A417 Missing Link
TR010056

8.22 Landowner Position Statements
(Rev 1)

A417 Missing Link

Landowner Position Statements (Rev 1)

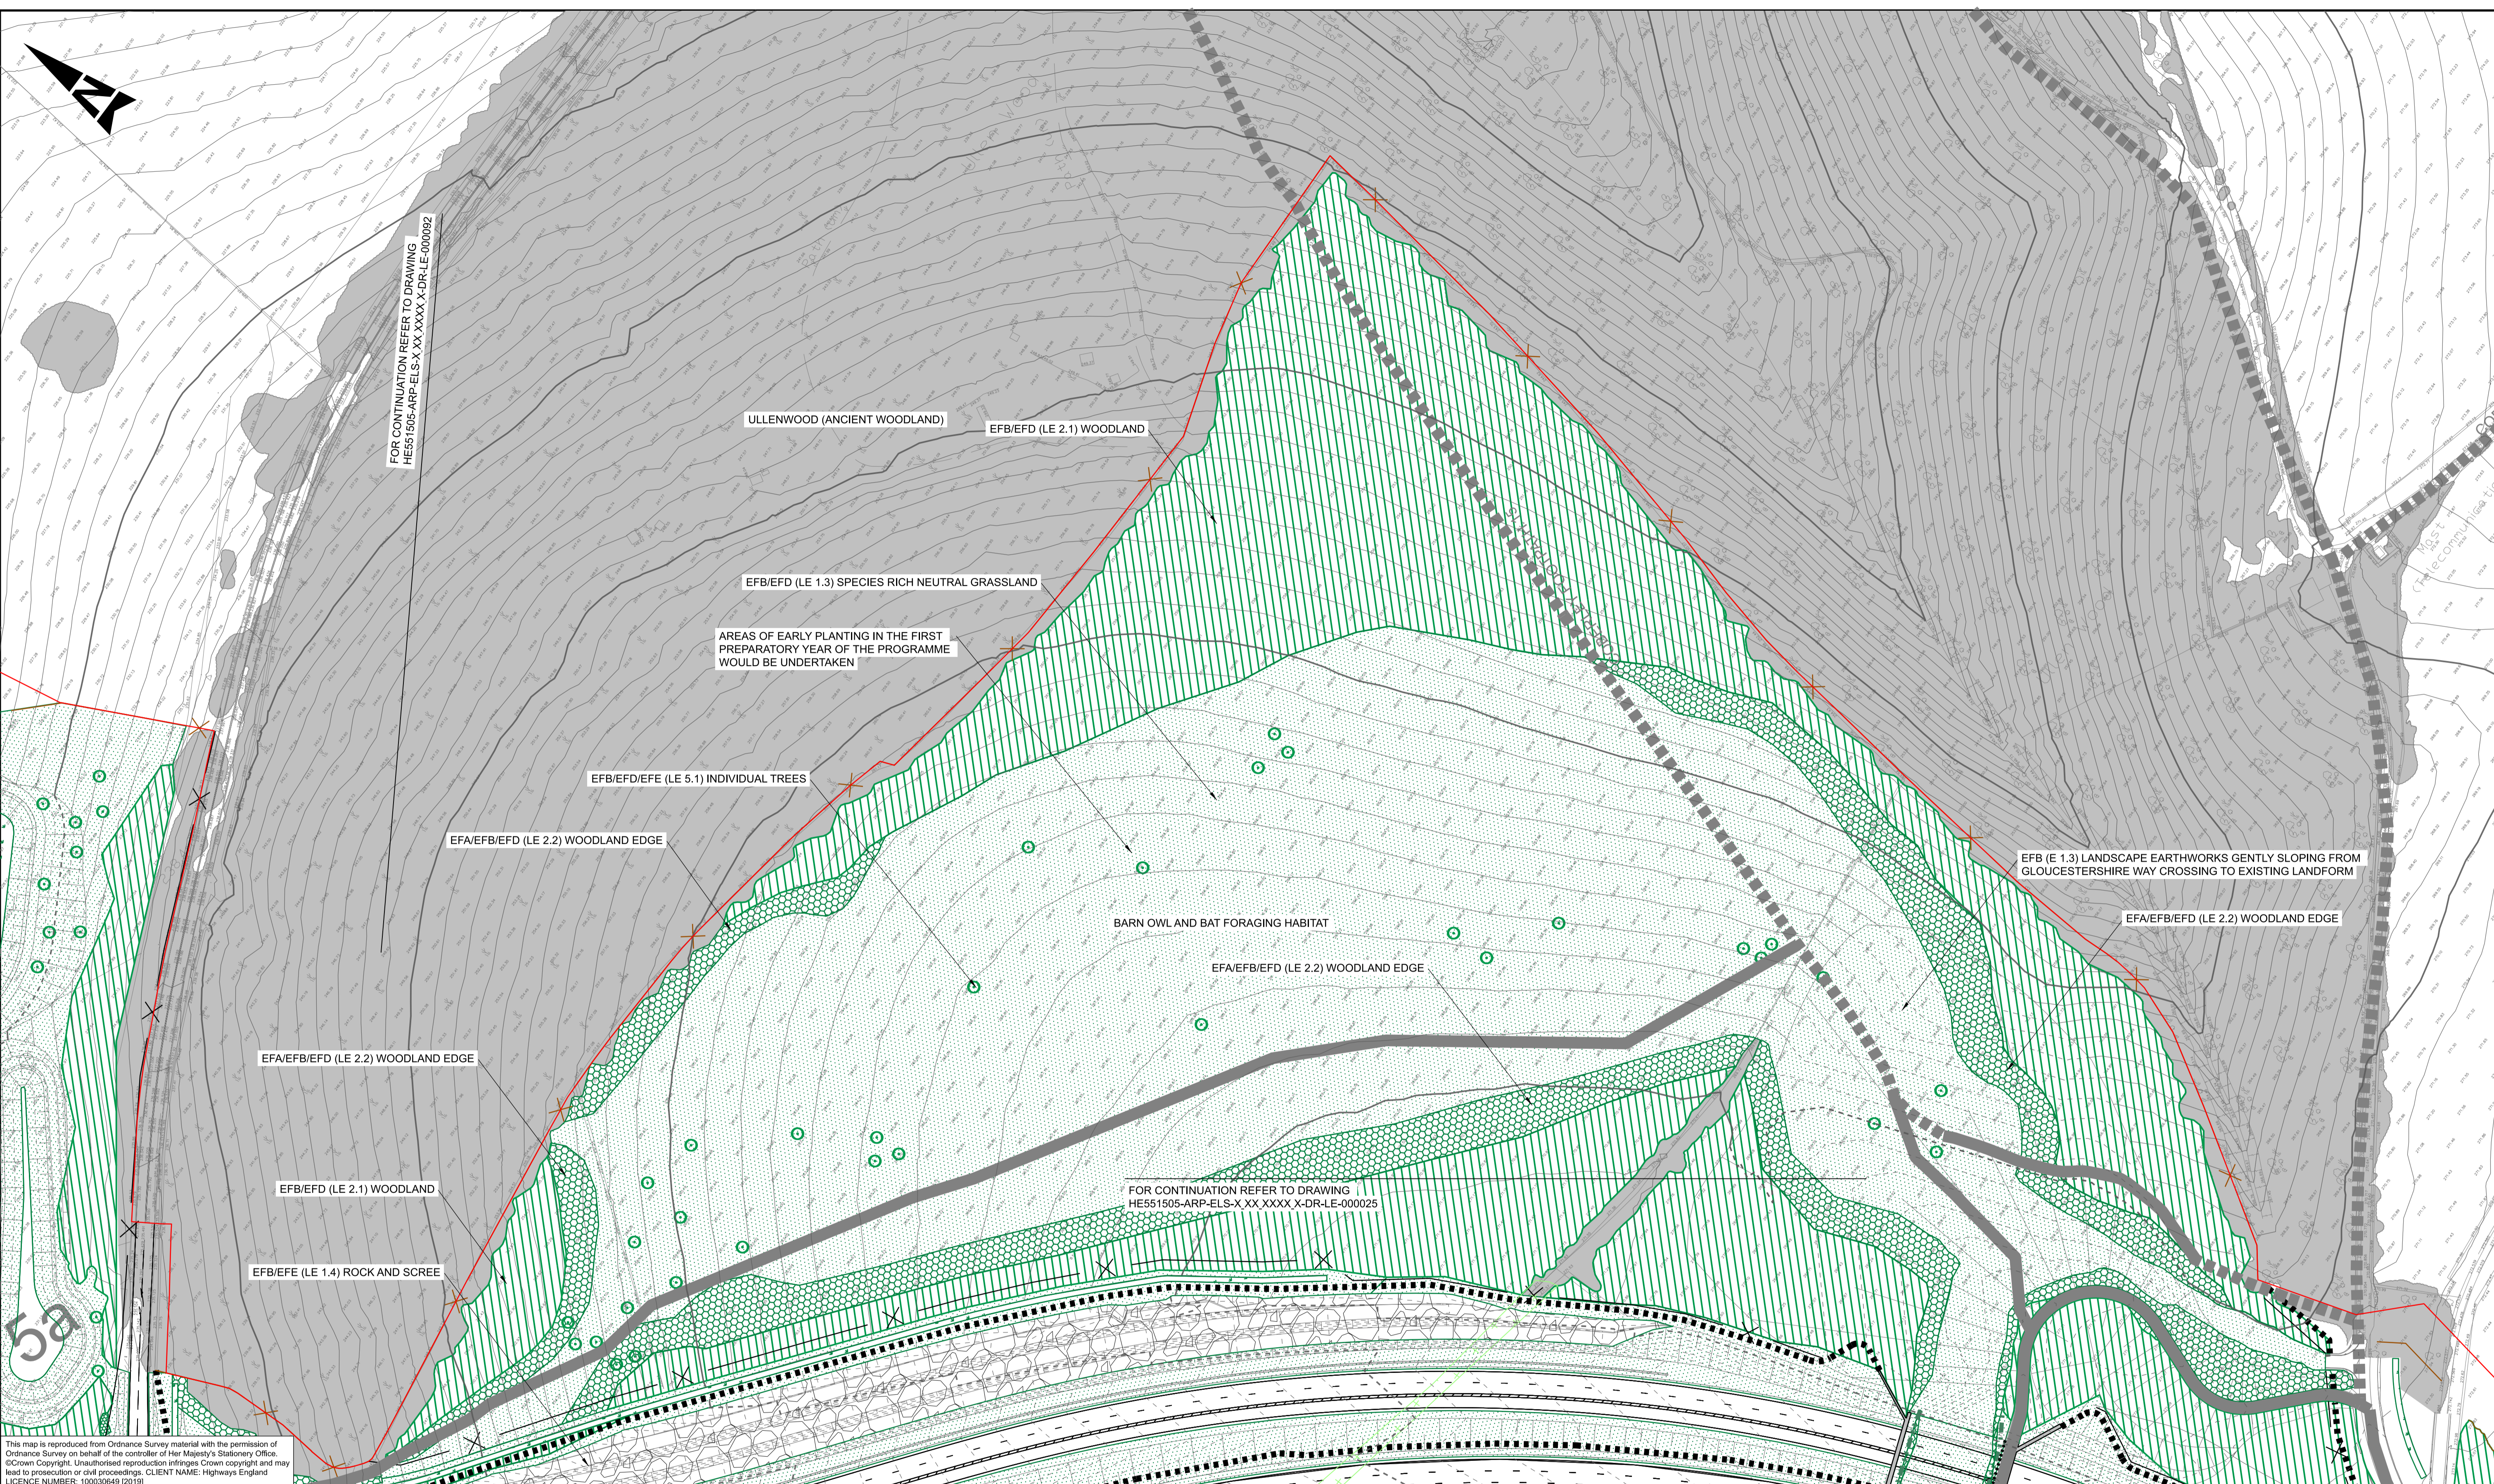
the survey area. Information on ecological surveys carried out for the scheme is provided in ES Chapter 8 Biodiversity (Document Reference 6.2, APP-039).
7	Ecological Mitigation	Ian Medlock challenged his land being acquired for the purposes of ecological mitigation as shown on Figure 7.11 Environmental Masterplan Sheet 8 of 25 (Document Reference 6.3, APP-175).	National Highways has considered the comments received from Ian Medlock. The ecological mitigation shown on Figure 7.11 Environmental Masterplan Sheet 8 (Document Reference 6.3, APP-175) has been identified as essential for the delivery of the scheme. The landscape design focusses on provision of priority habitats which are present within the Cotswold AONB; lowland calcareous grassland, lowland broadleaved woodland and native species rich hedgerows. The location and design of habitats has considered the draft Nature Recovery Network Map provided by Gloucestershire Wildlife Trust in 2020 and habitats required for specific ecological mitigation as described within ES Chapter 8 Biodiversity (Document Reference 6.2, APP-039). ES Figure 7.11 Environmental Masterplan (Document Reference 6.3, APP-175) provides green infrastructure which would help to deliver climate change resilience for both habitat and wildlife connectivity.
